From: David M Zabell
Sent: Wednesday, 7 August 2019 1:03 PM
To: Emily.Dickson@planning.nsw.gov.au
Subject: City of Sydney response to SSD 7484 Mod 4 - Sandstone Precinct - Changes to the Lands Building - R/2014/39/M

Thank you for inviting the City to comment on the proposed modification. City staff raise no objections subject to the following comments and recommendations being adopted:

- STATUS
- FOR APPROVAL**
- DRAWING TITLE
- DEMOLITION COURTYARD ELEVATIONS
LANDS BUILDING - NORTH COURTYARD
- DRAWING NUMBER **SP-DA-G-3150** ISSUE **02**
- Original Sheet Size B1-1000 x 707mm

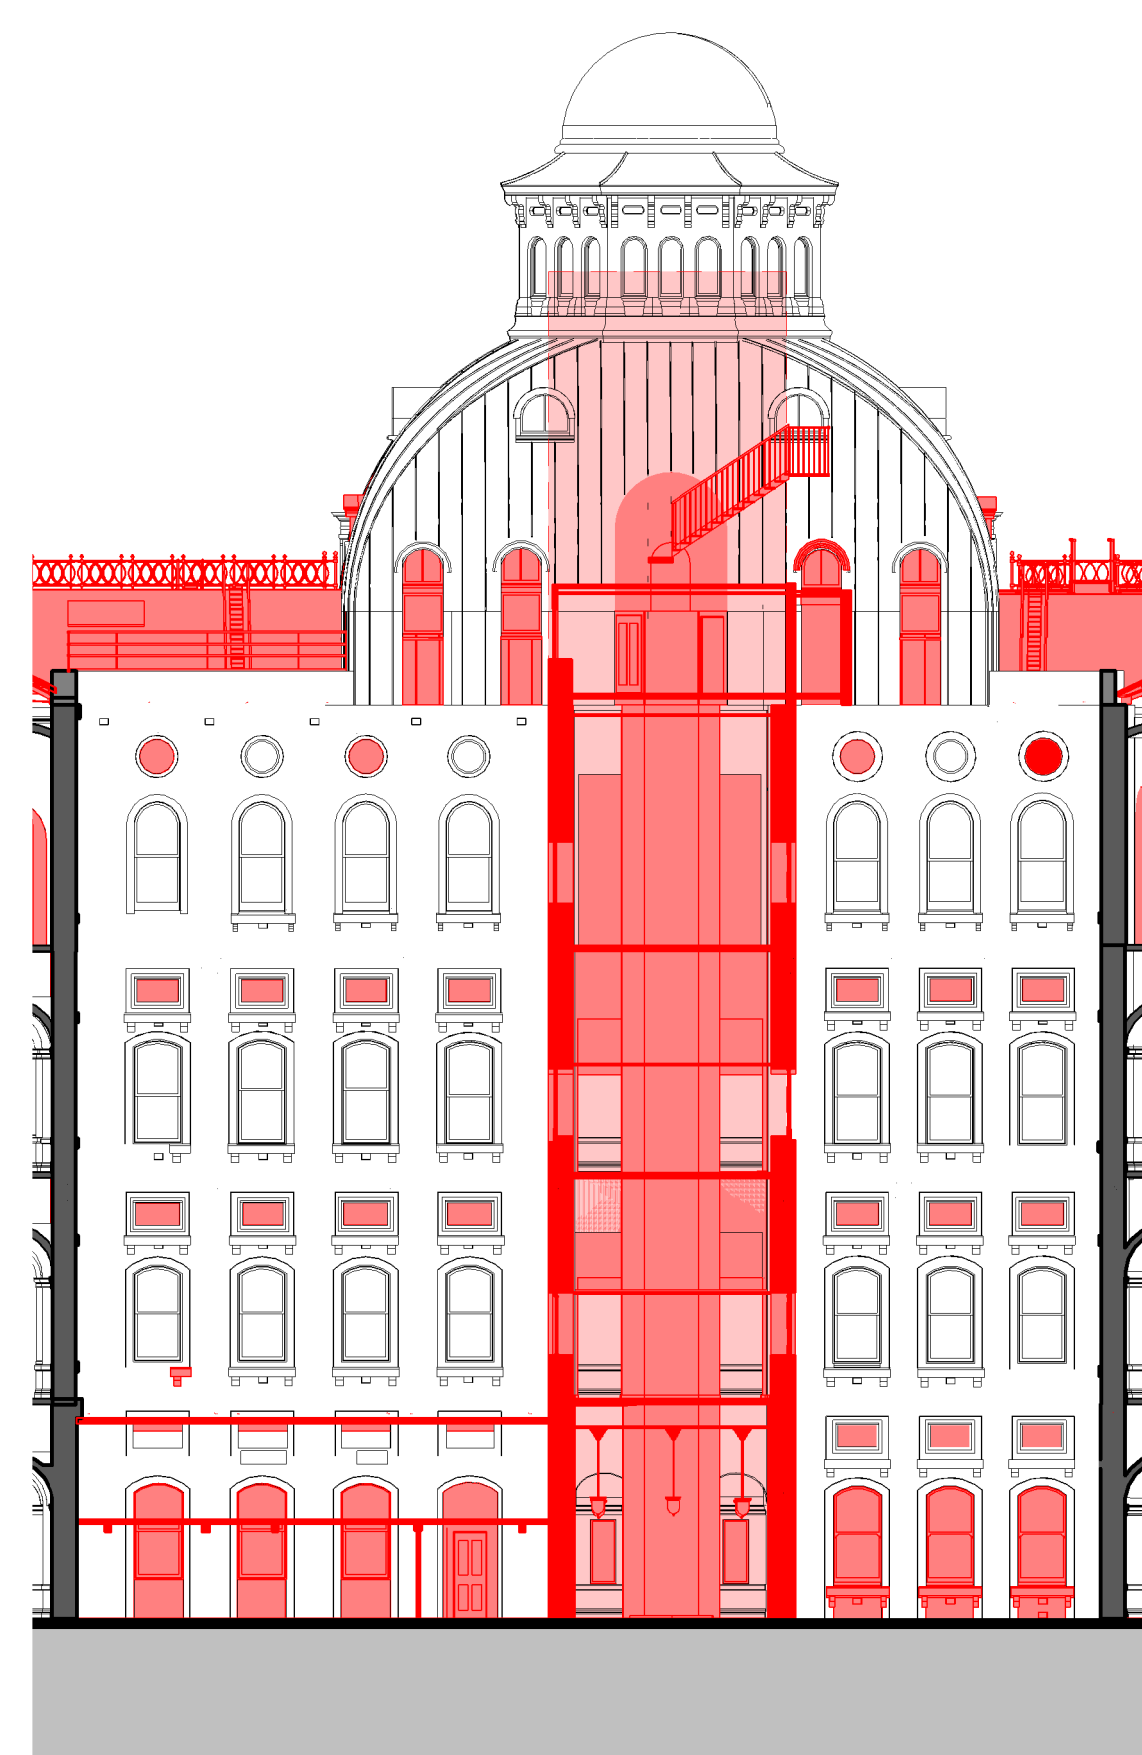
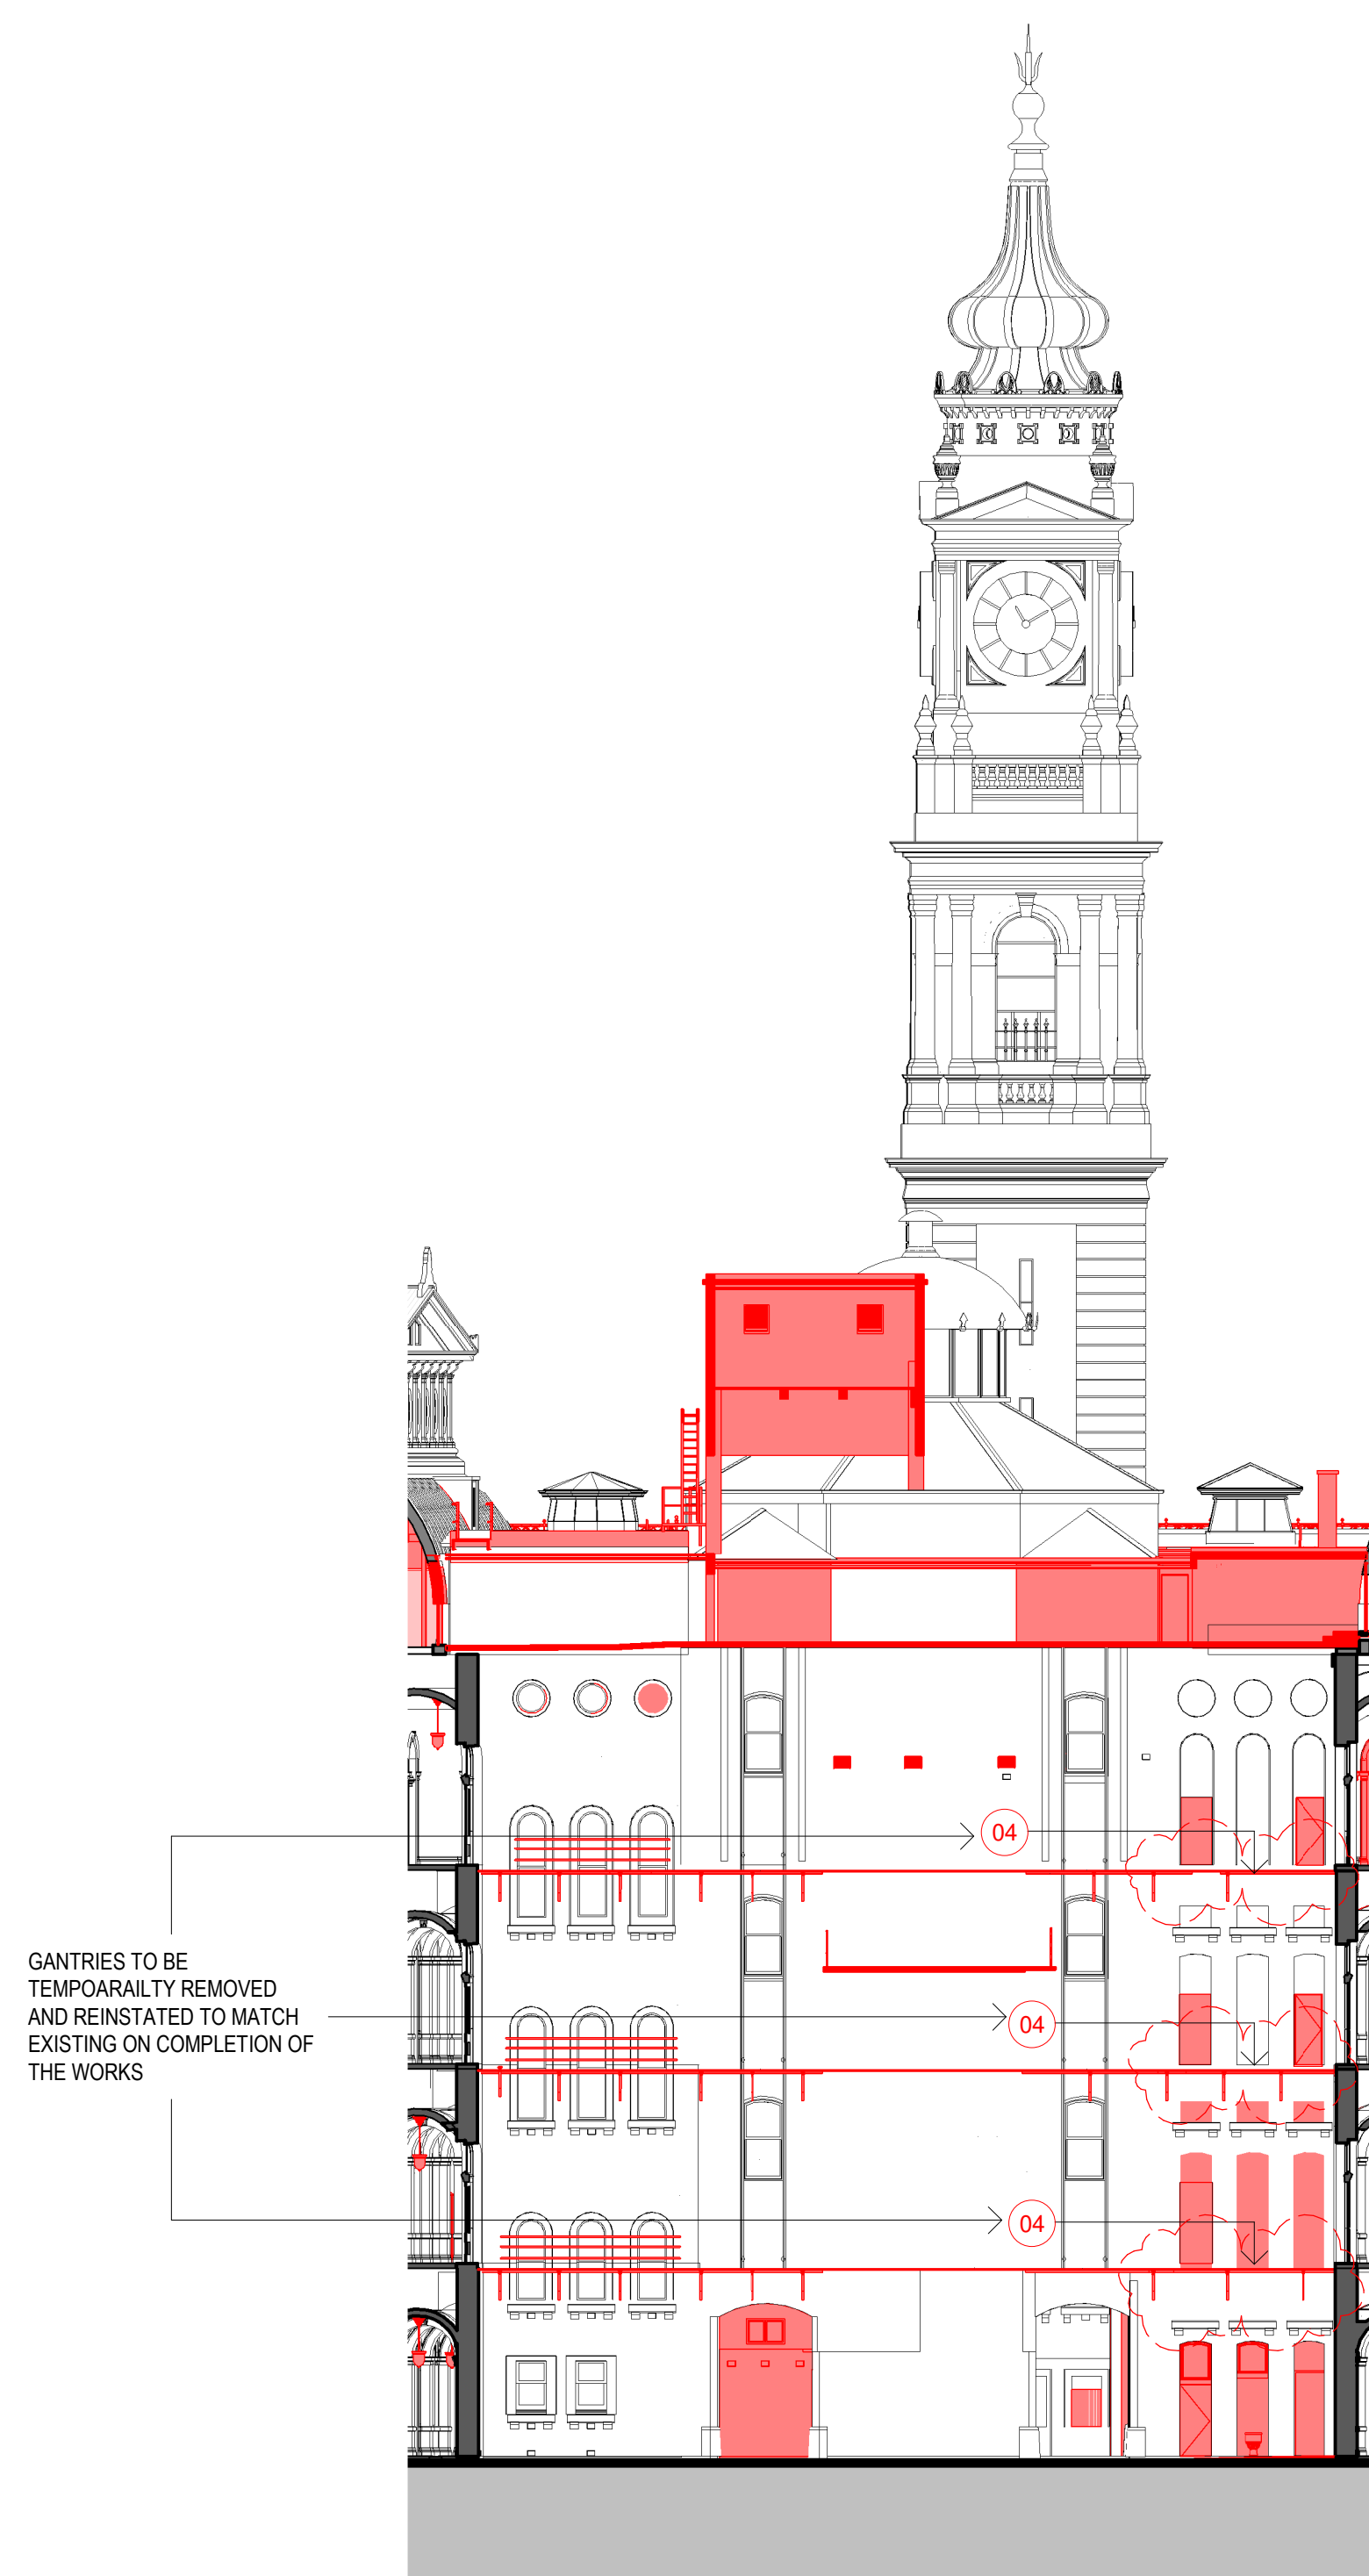
- The courtyard toilet structures and related iron gangways are early fabric and are not without significance. While 'cleaning up' the internal facades acknowledges their proposed public presentation to the courtyard circulation network, it should not remove all evidence of historic use. Retention of some ironwork in situ should be considered for interpretation. Substantial elements of the iron gangways, including the brackets should be salvaged for interpretation on site and the toilets should be covered in the revised interpretation plan.
